CITY OF ALBUQUERQUE

December 12, 2017

**RE: Fountain Hills Plaza Assisted Living
Grading Plan
Engineer Stamp Date: 12/06/17
Hydrology File: C12D003B8**

Based upon the information provided in your submittal received 12/06/2017, the Grading and Drainage Plan **is not** approved for Building Permit, Site Plan for Subdivision, Site Plan for Building Permit, and Grading Permit. The following comments need to be addressed for approval of the above referenced project:

FOUNTAIN HILLS PLAZA ASSISTED LIVING
GRADING PLAN

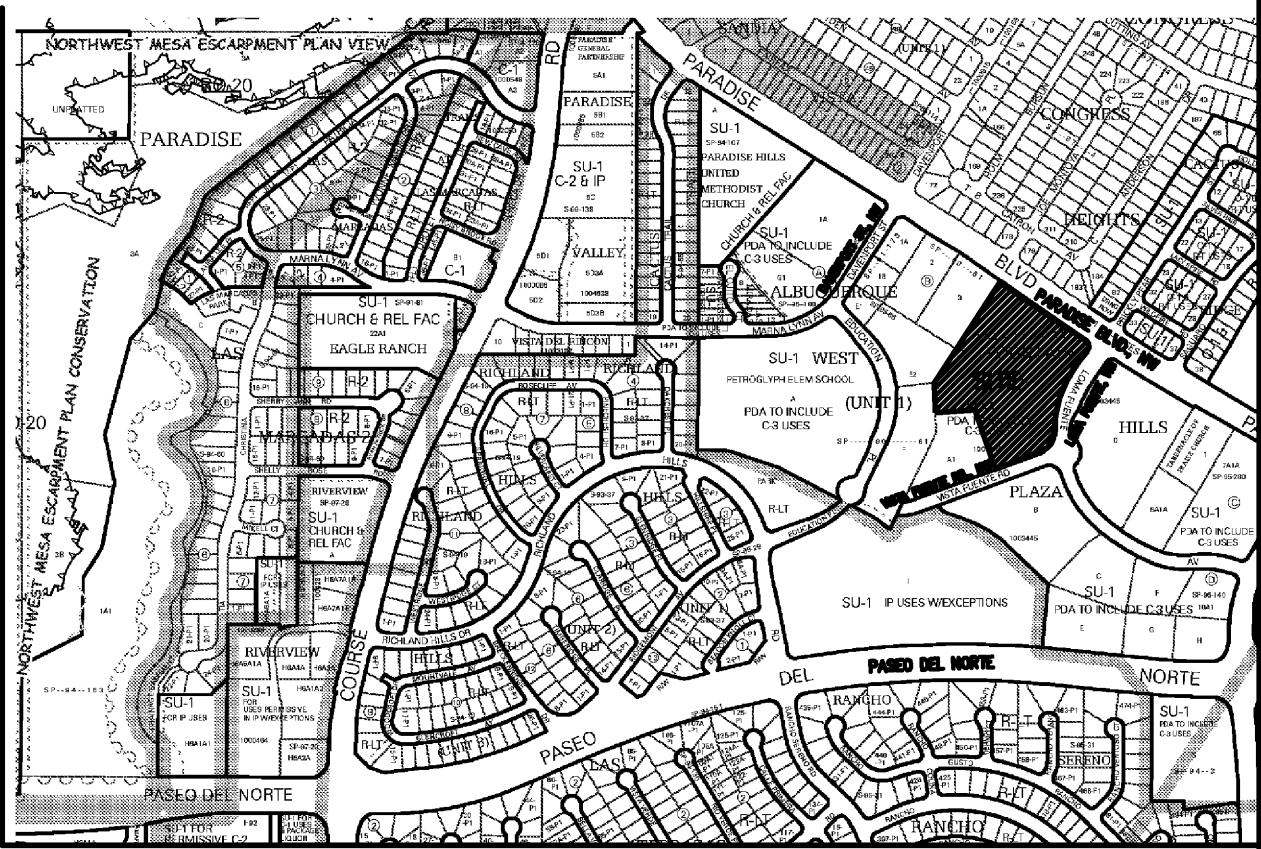
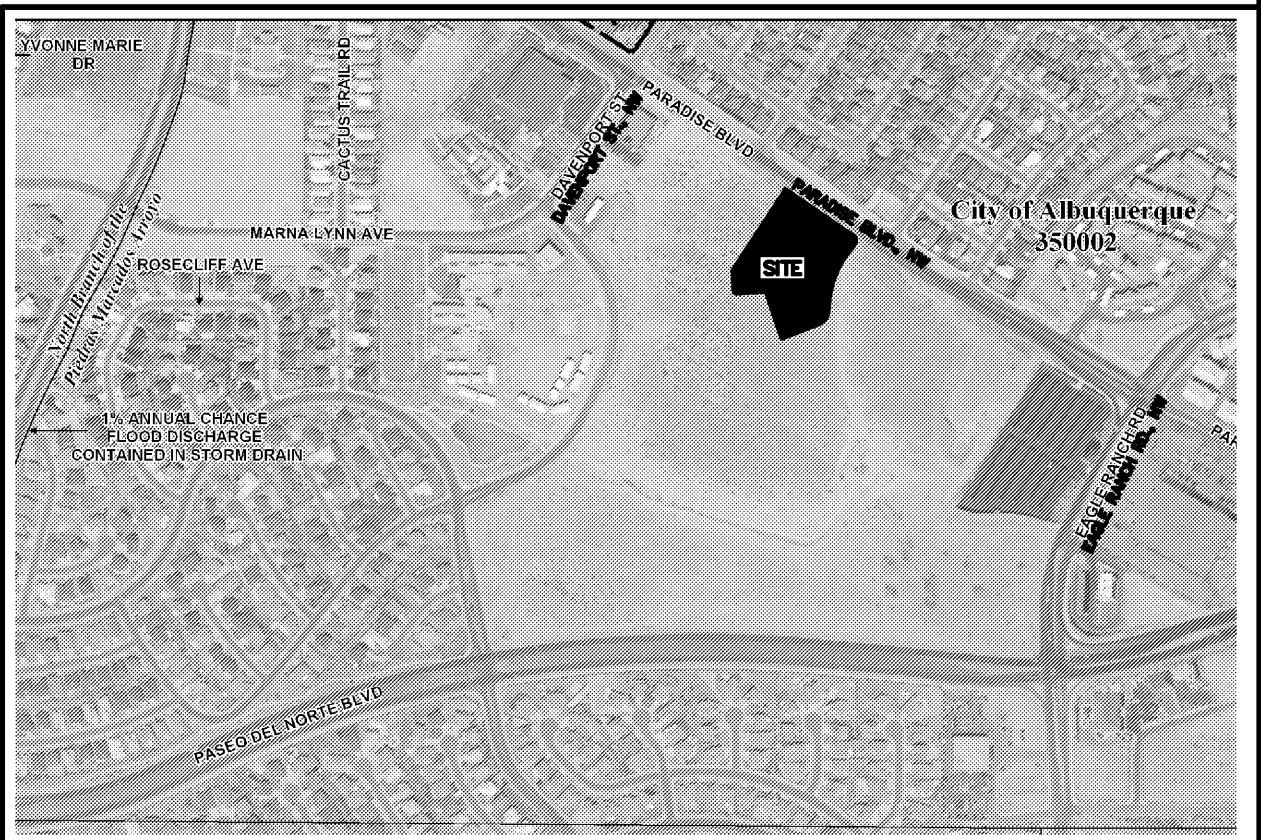
1. Please provide the flood plain effective date to the FIRM information.
2. Please label both adjacent streets.
3. Please show and label all nearby existing storm sewer. See attached as-built plan & profile for the storm sewer.
